**SSD-87041214, Corowa Battery Energy Storage System, 275 Whitehead Street, Corowa NSW, 2646;
Response to Environmental Impact Statement**

TfNSW has reviewed the Environmental Impact Statement (EIS) Revision 2, prepared by NGH and dated 06 March 2026, and the Traffic Impact Assessment (TIA), Reference: 1357 rep 260109, Revision B, dated 09 January 2026, prepared by Amber Organisation, as key documents for preparing this response.

**SSD-87041214, Corowa Battery Energy Storage System, 275 Whitehead Street, Corowa NSW, 2646;
Response to Environmental Impact Statement**

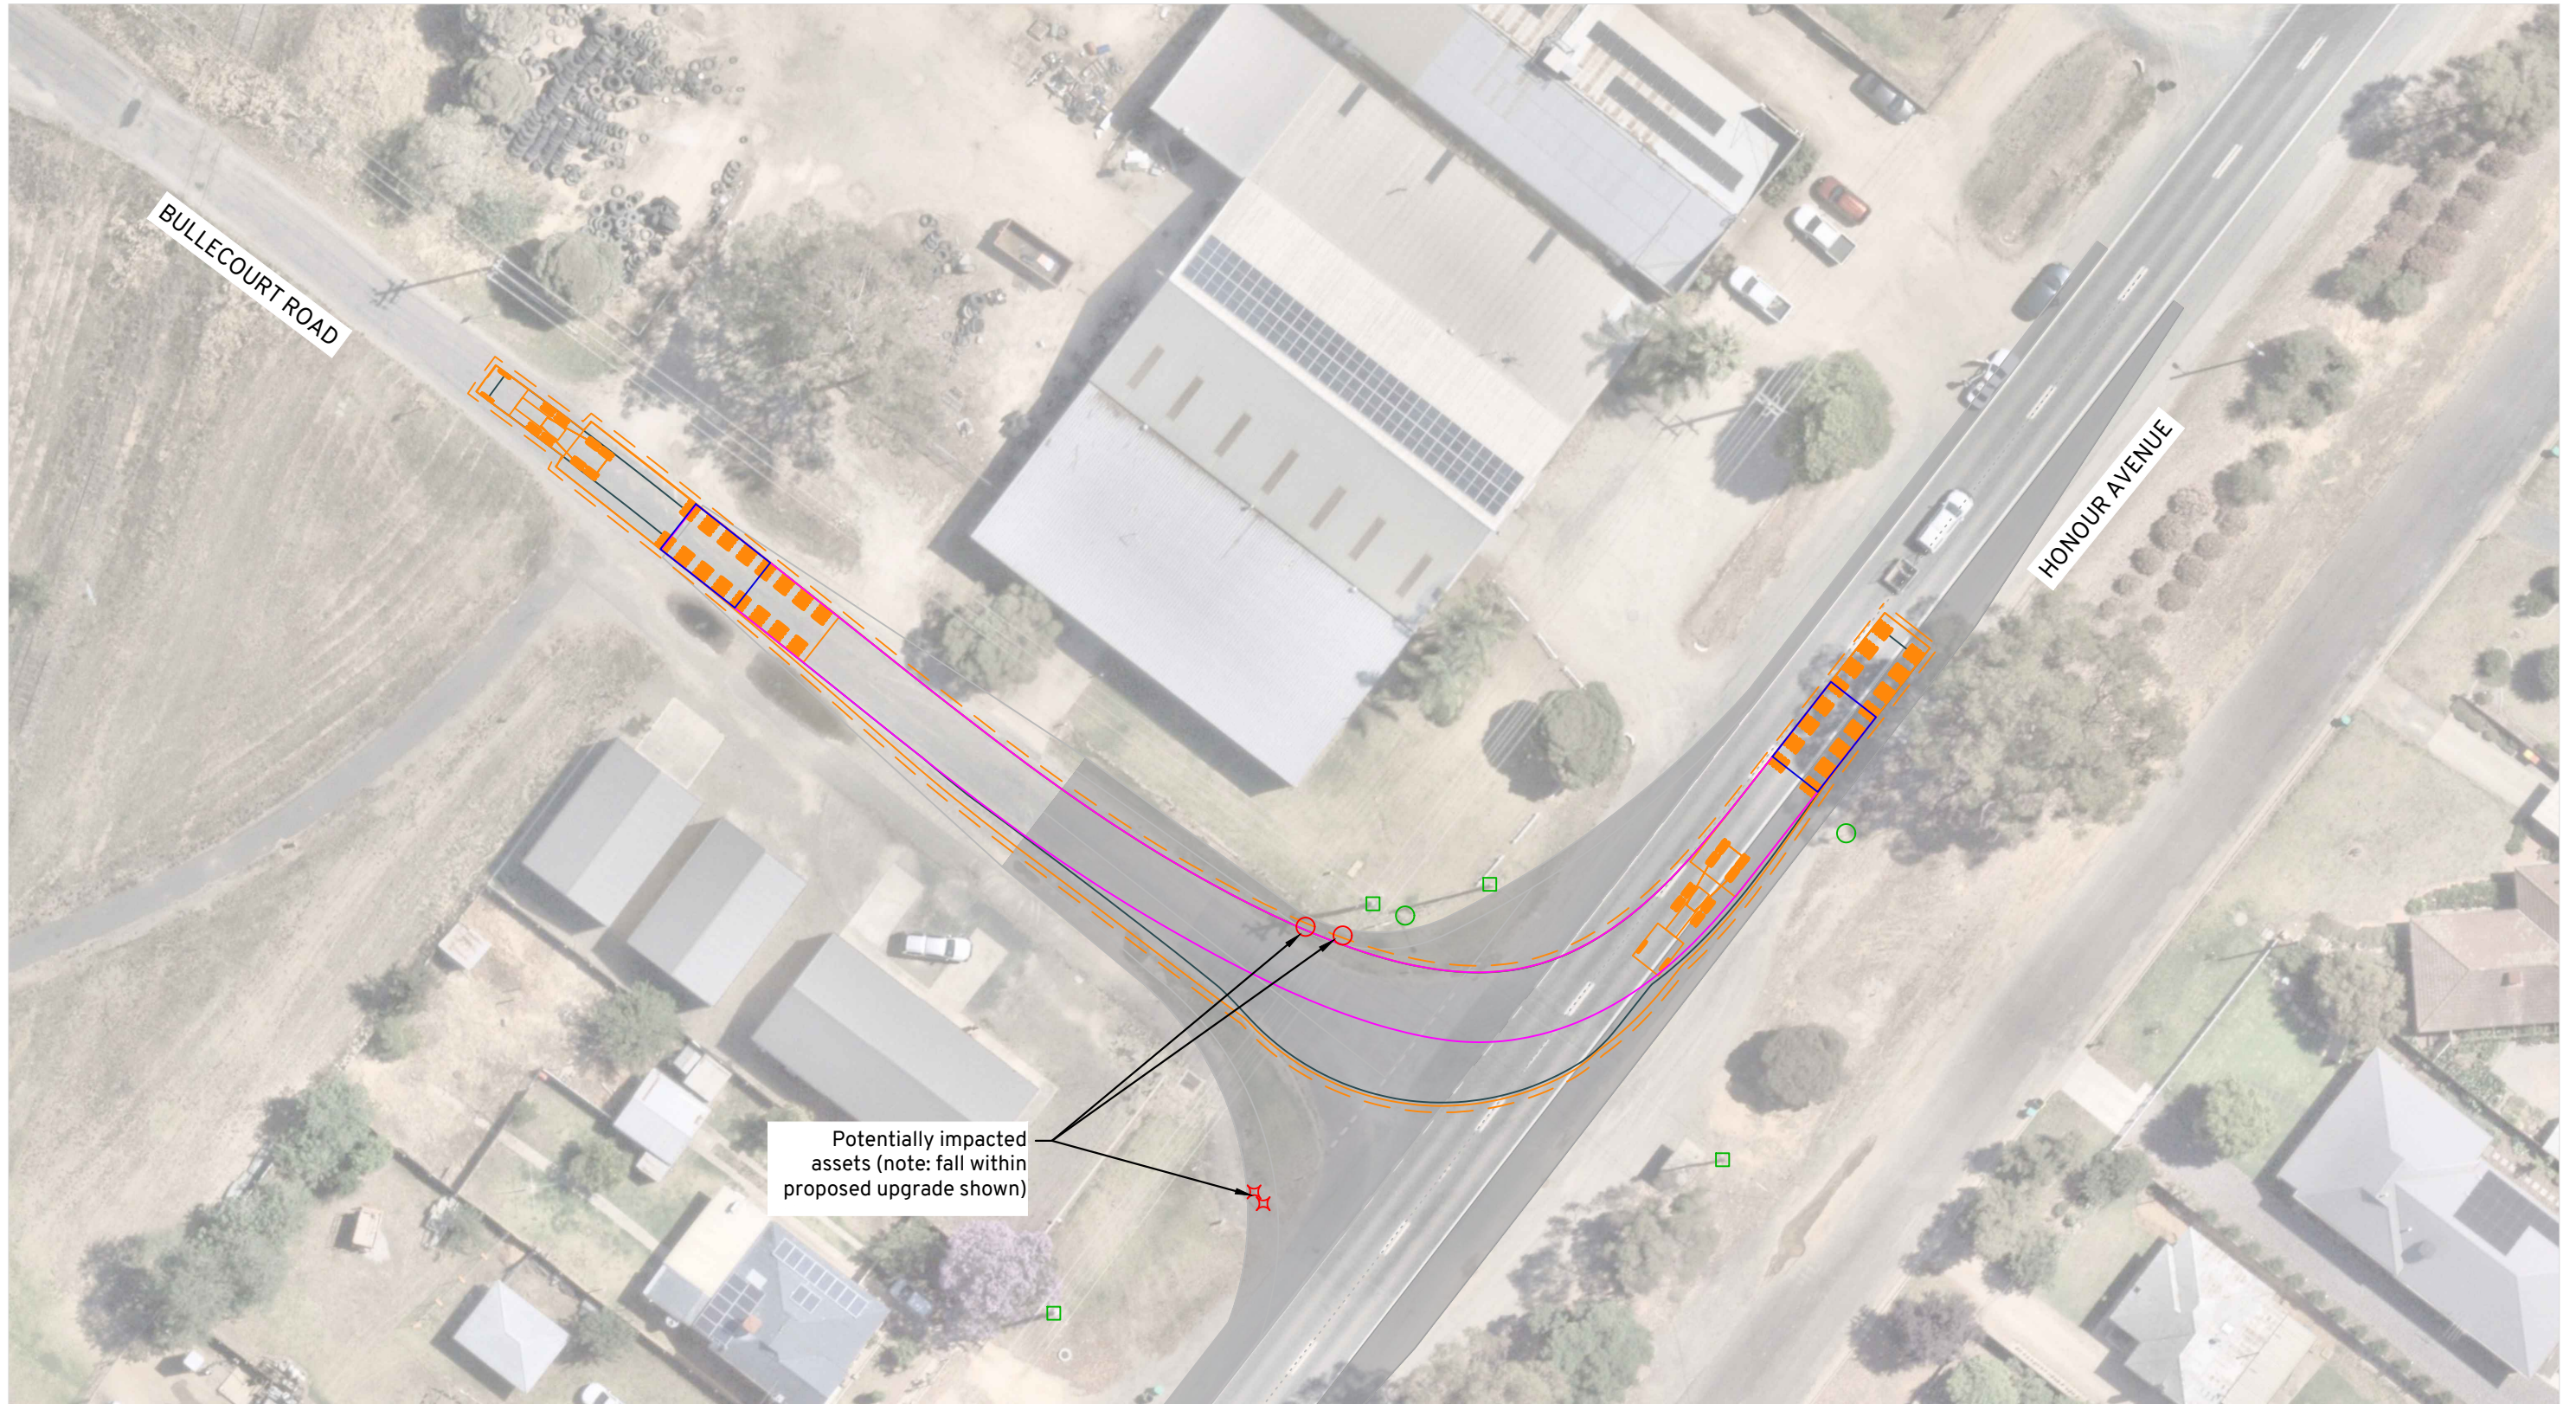
Sheet Reference: Amber 07 – Boundary Road onto Western Ring Road	The following is noted: - Escort vehicles to facilitate use of multiple/opposing lanes. - Spotters to ensure vehicle and load are clear of infrastructure

Further clarification is sought on how this movement will be managed. Is it proposed to be widened? Is line marking proposed? Will a TGS and traffic control be required?	
Pre-construction Minor Works assessment requirements			
2.	A targeted assessment of pre-construction minor works is requested. Refer to Attachment 2 for the pre-construction minor works assessment requirements.		TIA to be revised to address this requirement.
Rail			
3.	The applicant must submit a permit application via the National Heavy Vehicle Regulator (NHVR) to use the subject public level crossing. Should the applicant intend to use any other UGLRL-managed CRN assets or infrastructure, including level crossings, overbridges, or underbridges, for OSOM or heavy-vehicle movements, approval must be obtained from the NHVR prior to use.		Post consent requirement.
